M3 Junction 9 Improvement Examination: Deadline 1, Post-hearing submission from Cycle Winchester.

6 June 2023

DRAWING TITLE  
 FIGURE 2.6 - THE SCHEME: TEMPORARY DIVERSION OF WALKING, CYCLING, AND HORSE RIDING ROUTES APFP REGULATIONS 5(2)(a) DOCUMENT REFERENCE 6.2

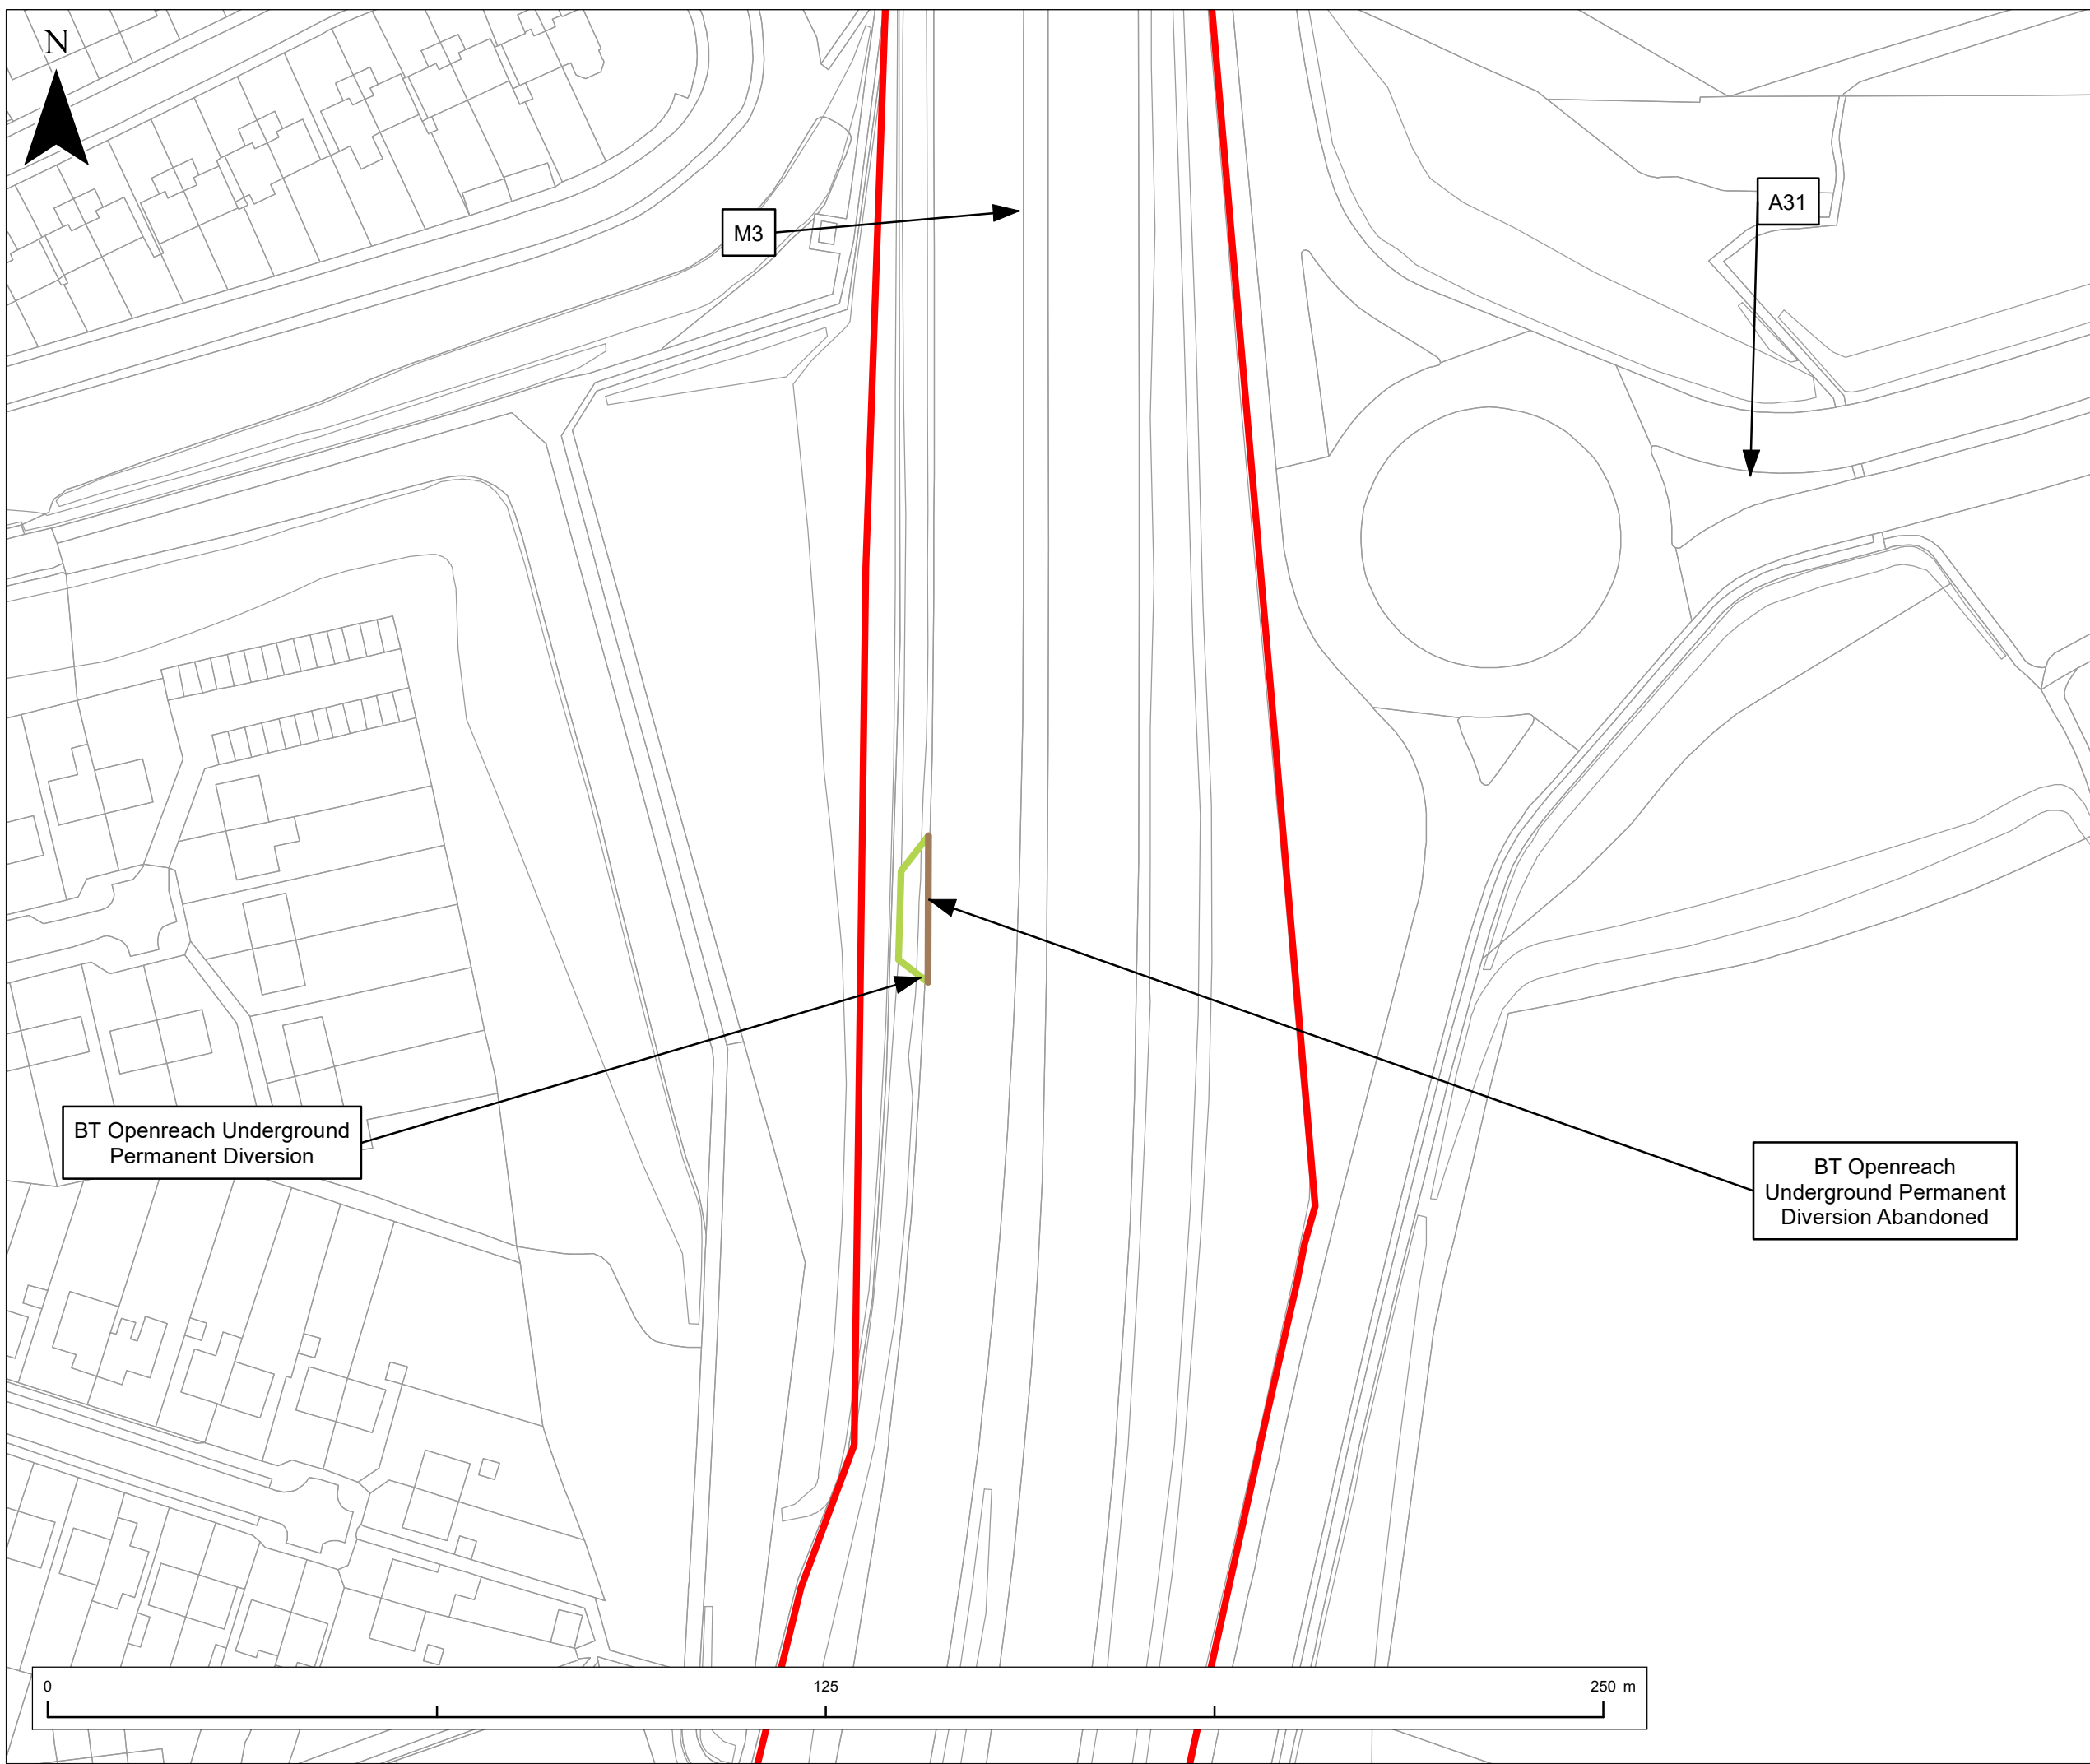
On that second point, we expressed concern that, despite assurances from National Highways that no decisions had been taken on non-motorised diversions, and that we would be consulted before any were proposed, in fact the submitted plans included a detailed diversion route during construction. The proposed diversion is both illegal and physically impossible for cyclists and equestrians to use, including as it does two public footpaths, two stiles, and a bridge with clearance so low that even pedestrians have to duck when using it. Bear in mind that this is a diversion for a well-used National Cycle Network route. We're very concerned about this, as it suggests that despite all the good work so far, National Highways is still not taking the requirements of non-motorised users seriously. As noted by other representations at the OFH, the lack of a satisfactory diversion during construction will result in residents of Easton and the Itchen Valley, who happily visit shops in Winnall by bicycle or on foot, instead getting into their cars for this short journey; the exact opposite of behaviour we want to encourage.

We were questioned by the examiners on suitable alternative diversions, and while this decision depends very much on related plans for motorised diversions, we mentioned two possible routes:

- Long Walk, Fair Lane and Alresford Road (B3404), and
- Easton Lane and Martyr Worthy Road (B3047).

Alresford Road is very busy and cyclist-hostile, so National Highways should be looking at funding mitigation measures to make it more suitable as an alternative cycle route, if that is their preferred option. Both are very much longer than the current NCN23 route, so the duration of diversionary period would need to be as short as possible. We request National Highways to document their proposed diversion – one that is legal, practical, and with appropriate mitigations for cyclists' safety – at the earliest opportunity.
